Subject: FW: fao Stephen Dukes - application 23/0610/OUT

Thank you for your letter of 21 August 2023 regarding application number 23/0610/OUT - outline application for residential development of 3 dwellings with associated infrastructure at Church Farm Station Road Elmesthorpe.

The Parish Council wishes to object to this application on the following grounds:

BLOCK PLAN AS PROPOSED

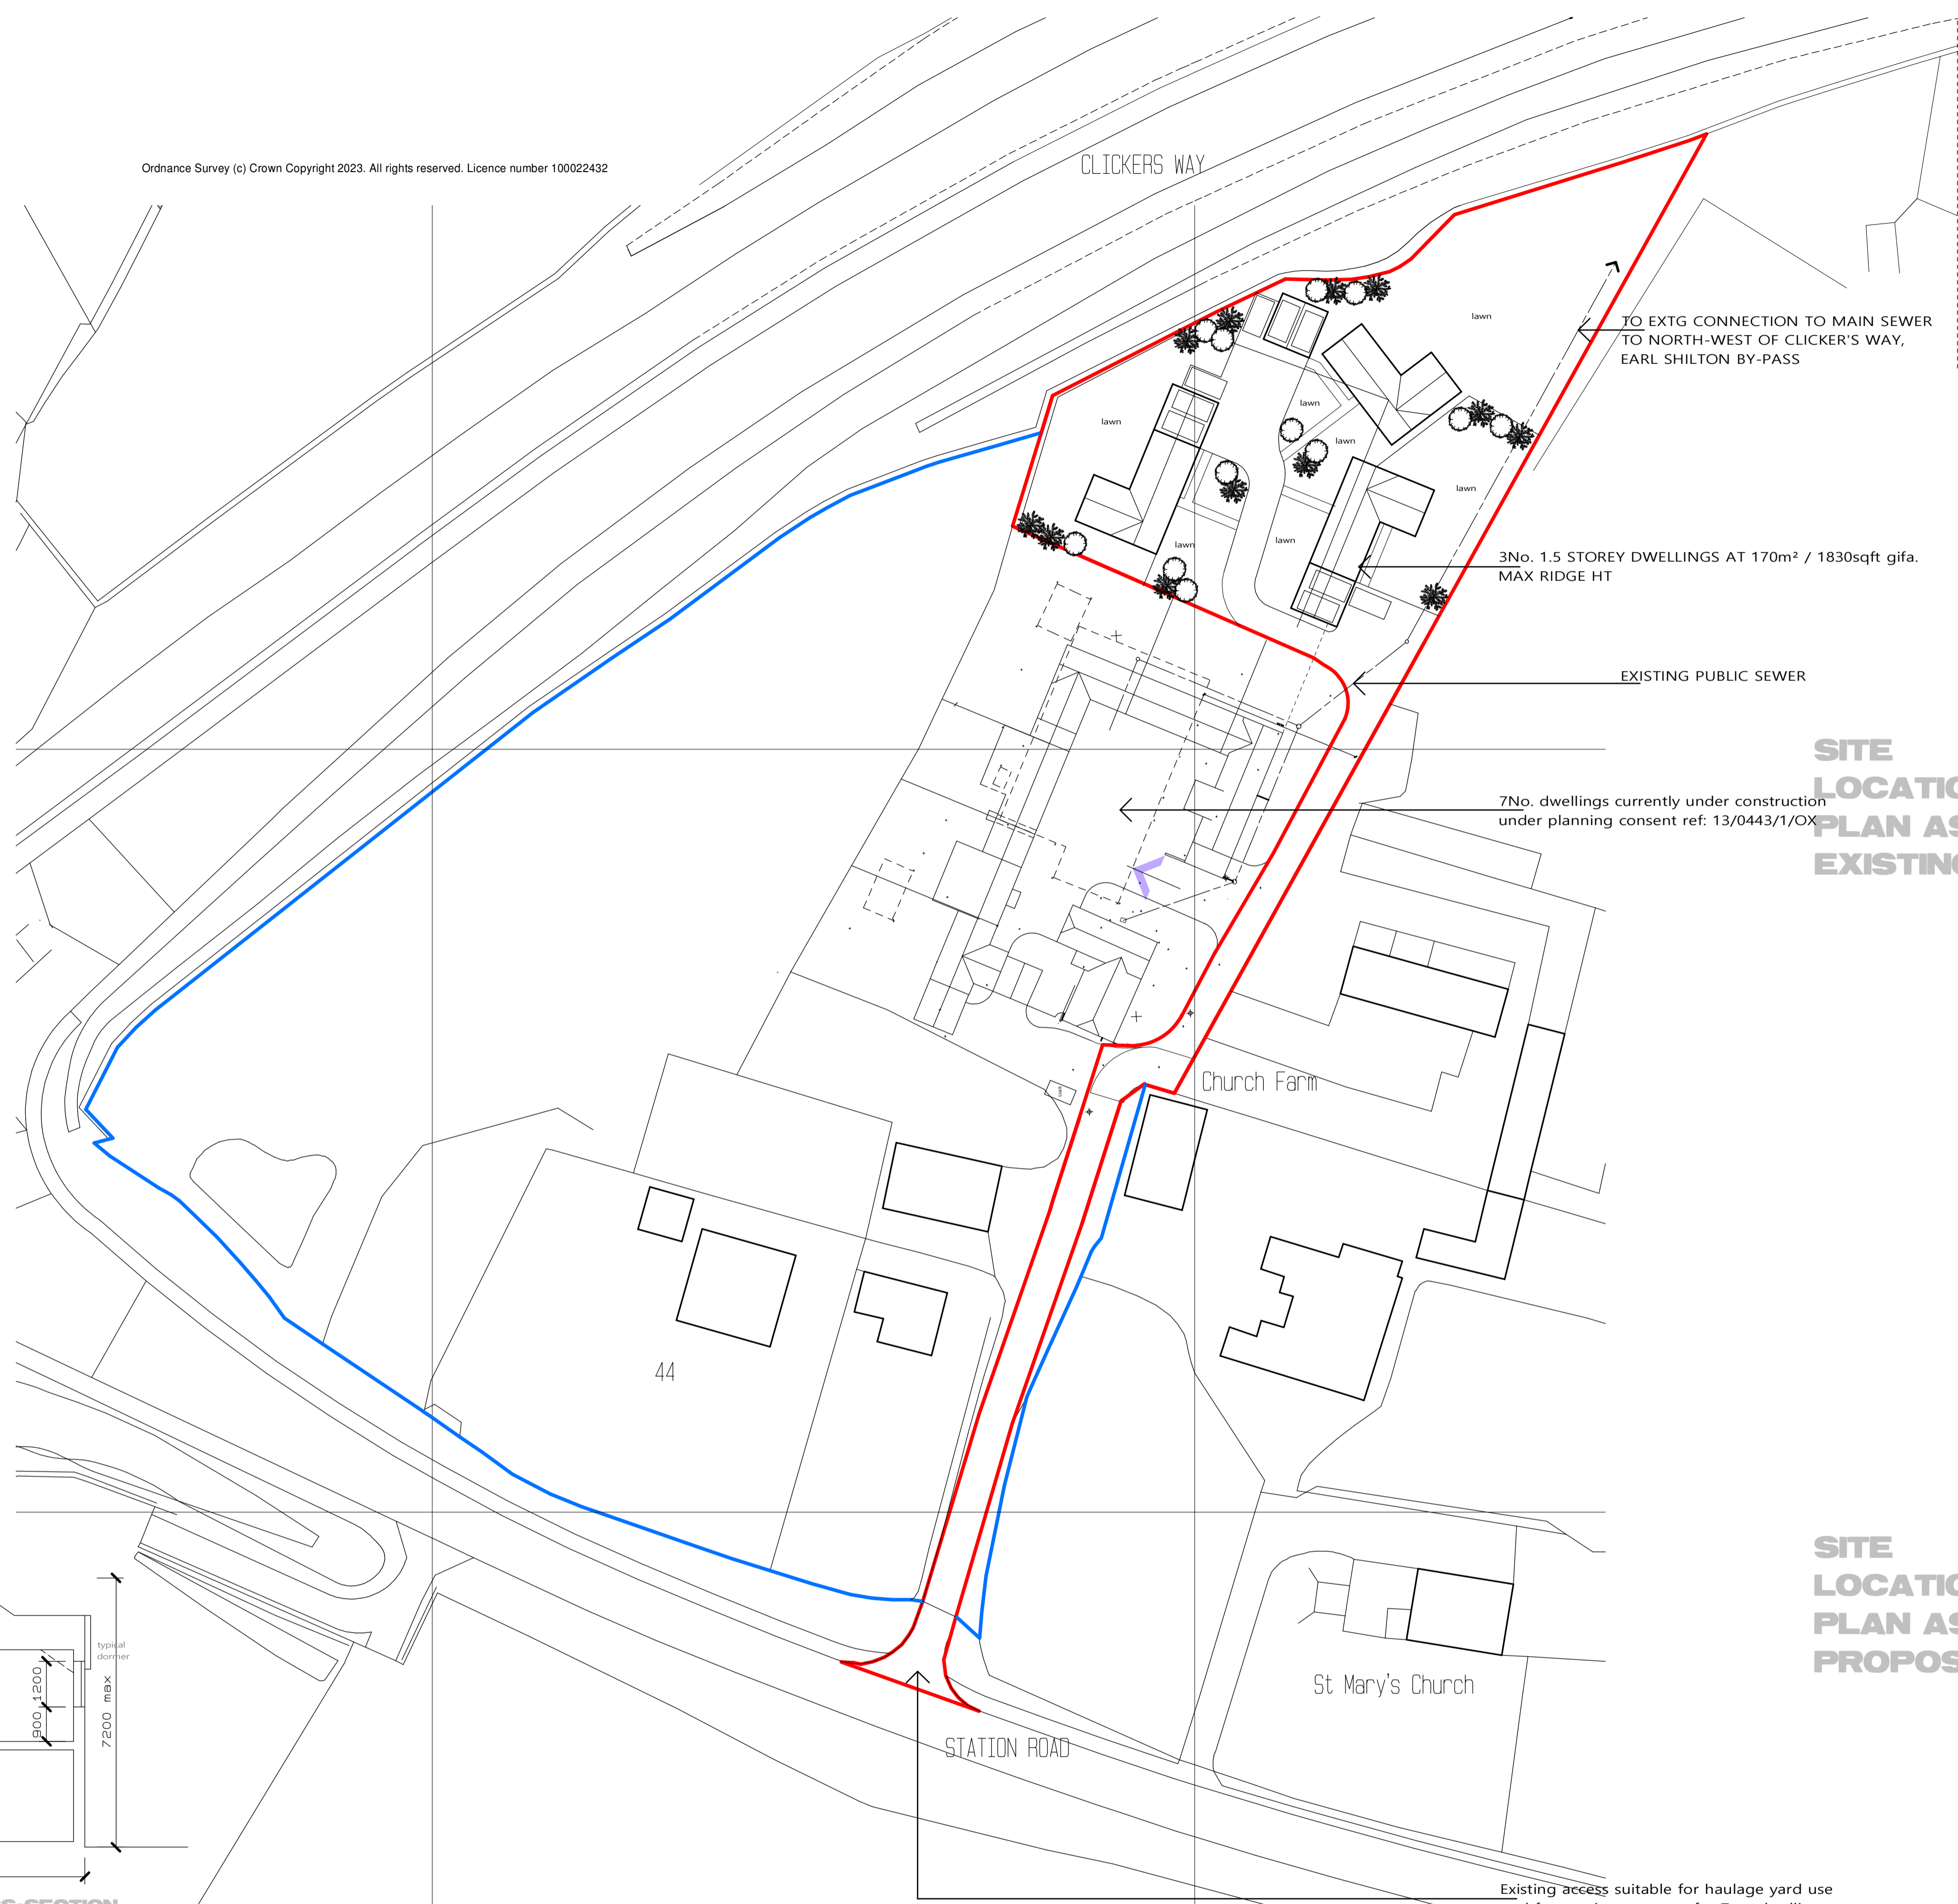
7. The Parish Council would also ask that an assessment is made of the suitability of the access and available space within the application site to manoeuvre emergency vehicles such as fire engines due to its distance from the public highway.
